Request sketch plat review to vacate a public water and sewer easement from 3 existing lots, to create three new lots and grant a new public water and sewer easement further west from the vacated one. Utility plans for water and sewer, as well as the recorded IIA are provided.

Re: Sketch Plat Review for Subdivision to create Proposed Lots 2-A-1 thru 2-C-1, Tract S-1 of Atrisco Business Park, Unit 2, being comprised of Lot 2-A thru 2-C, Tract S-1 of Atrisco Business Park, Unit 2

Cartesian Surveys is acting as an agent for Ray's Flooring Specialist Inc. and we request a sketch plat review of our proposed subdivision to vacate an existing public water and sewer easement, creating three (3) new lots from three (3) existing lots: Proposed Lots 2-A-1 thru 2-C-1, Tract S-1 of Atrisco Business Park, Unit 2, being comprised from Lot 2-A thru 2-C, Tract S-1 of Atrisco Business Park, Unit 2. The property is located at 7401 Los Volcanes Road NW, between Ben Keith Way and Airport Drive NW.

**AS102 TCL**

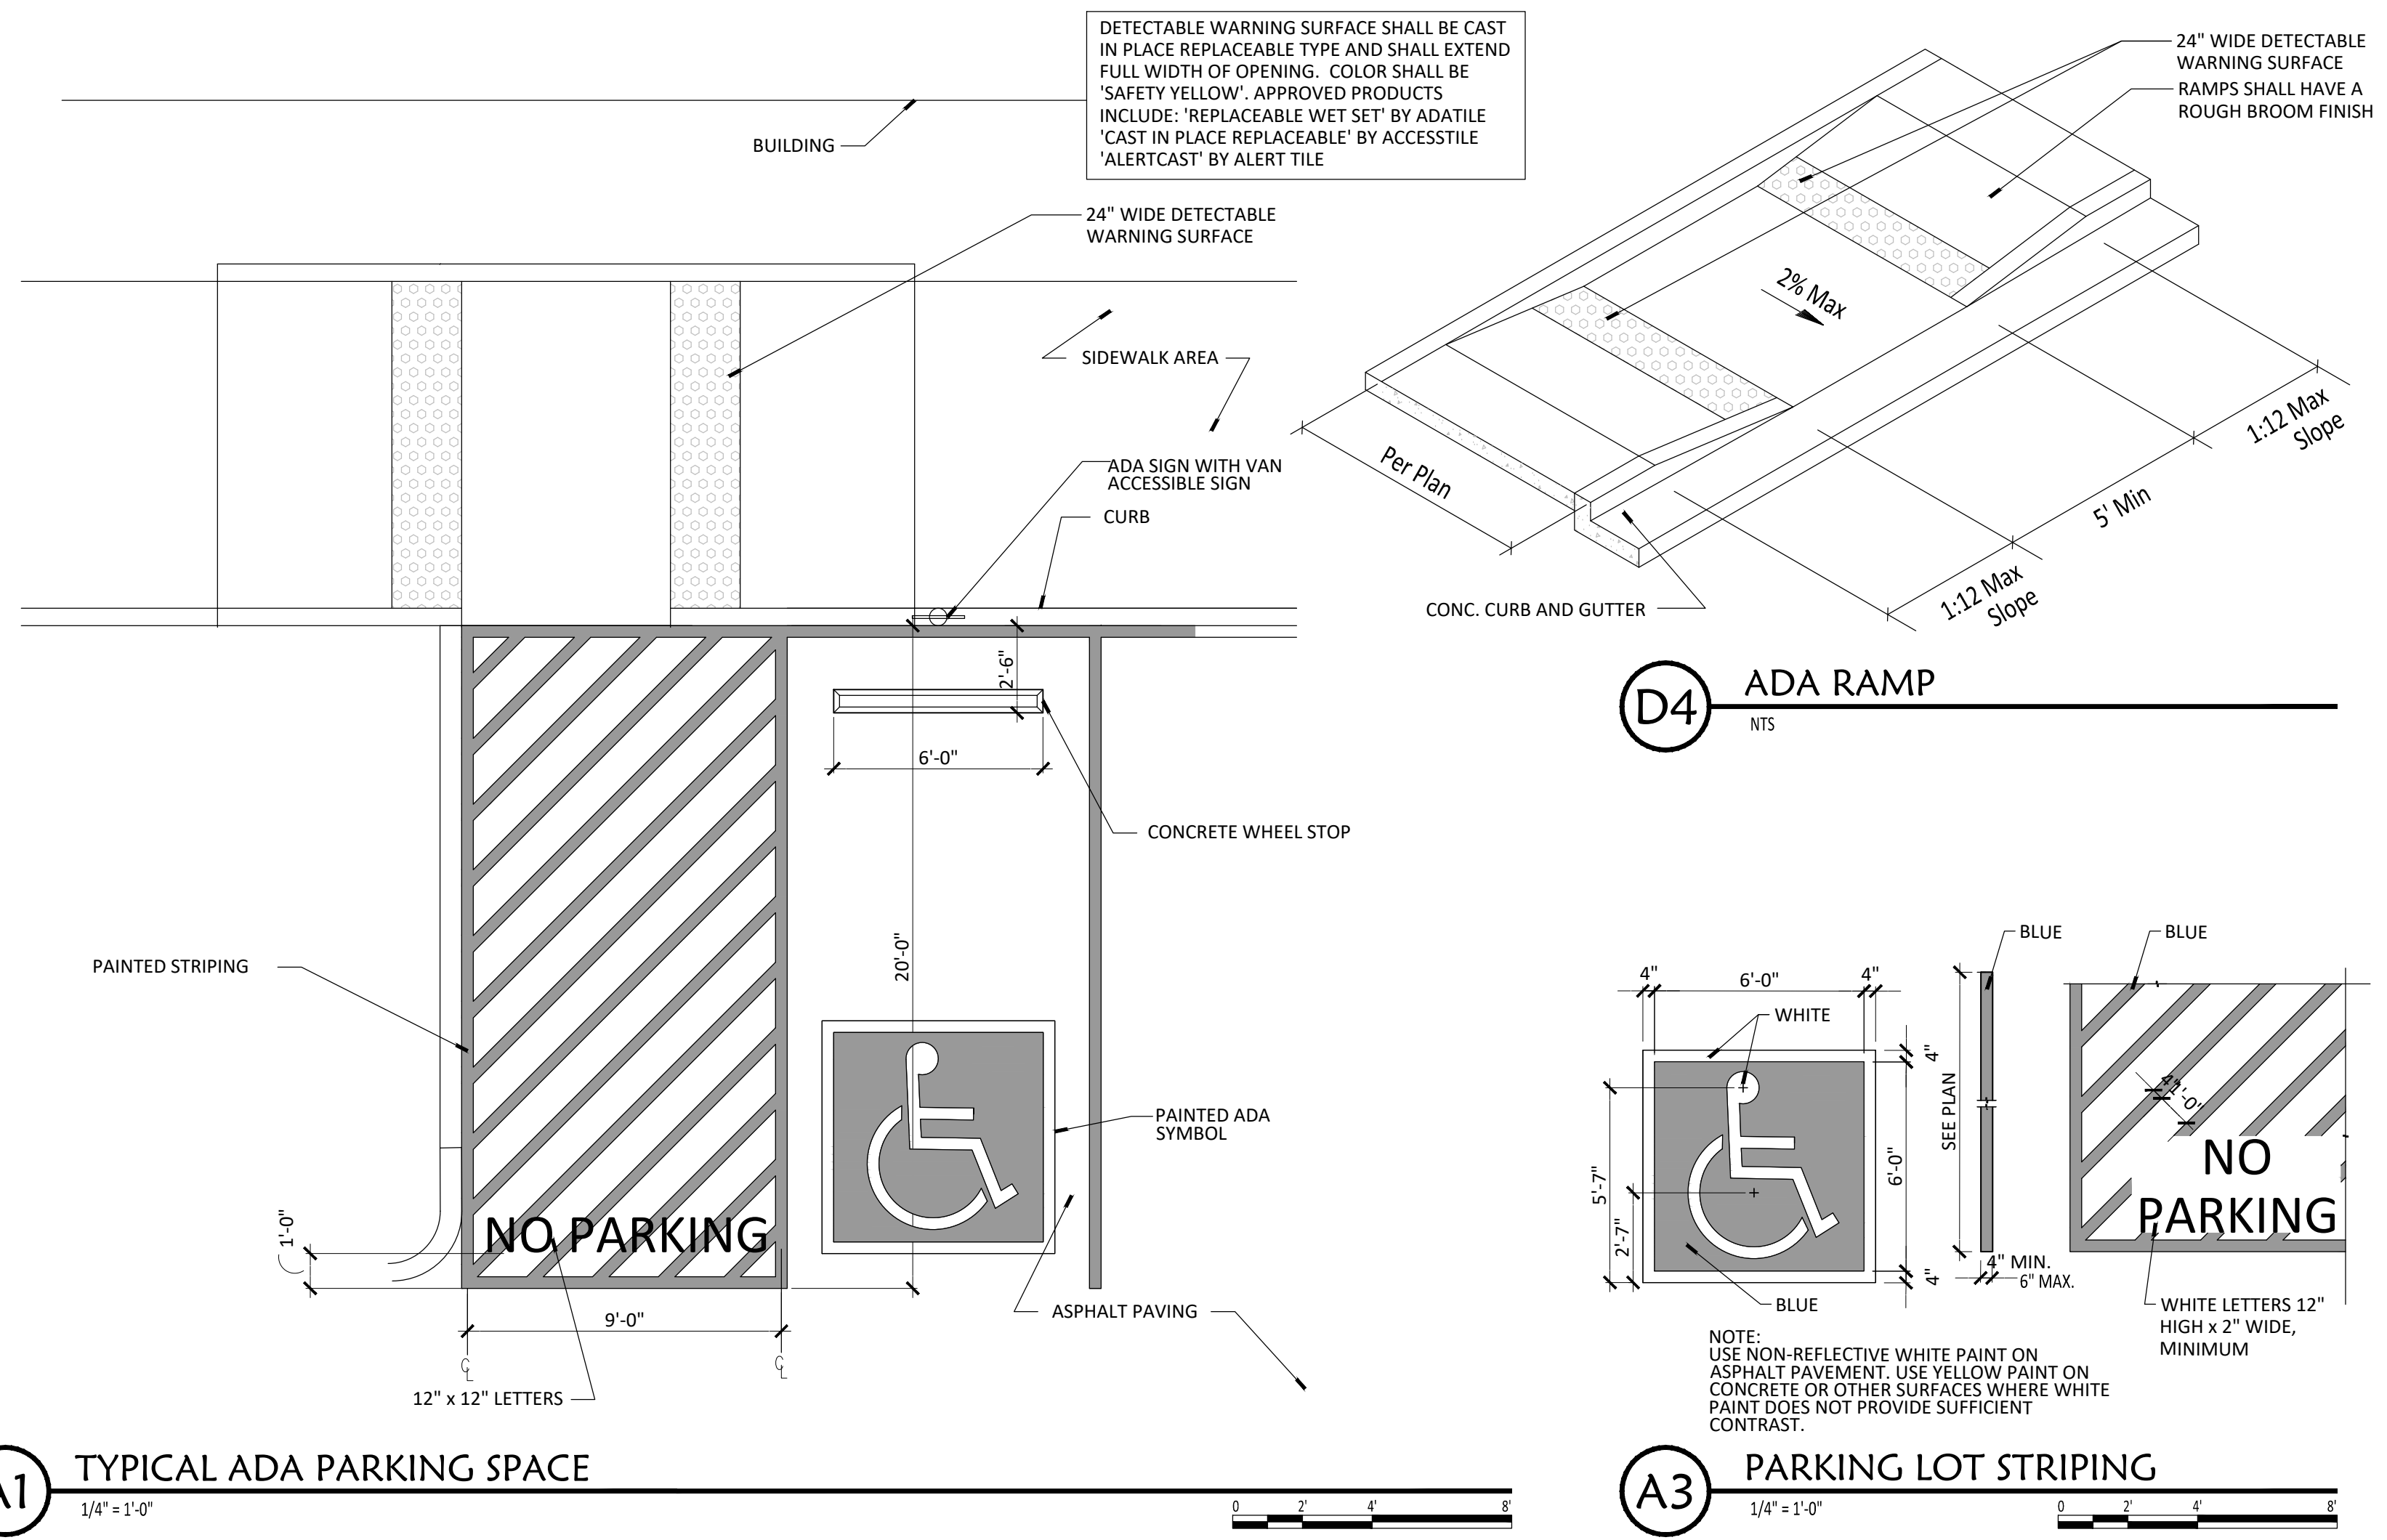
2. For any future development, a Traffic Circulation Layout will be required prior to Building Permit. Please ensure all lots meet parking requirements for the development currently on each proposed lot.

♣ Please clarify if parking and landscaping if affected by replat? Please confirm that parking and landscaping requirements are being met for the current site and if a shared parking agreement is a part of the new development?

Noted, parking counts are provided in the associated site plan attached and are covered by a parking agreement also provided in this supplement.

Noted, dedication of additional right-of-way to Los Volcanes Rd NW has been provided to accommodate 6-foot sidewalk and 5-foot landscape buffer. Parking requirements are shown to be met by a parking agreement, easement [5], and the attached parking counts from the anticipated site plan. See attached TCL pages and above explanation for code enforcement for specifics.
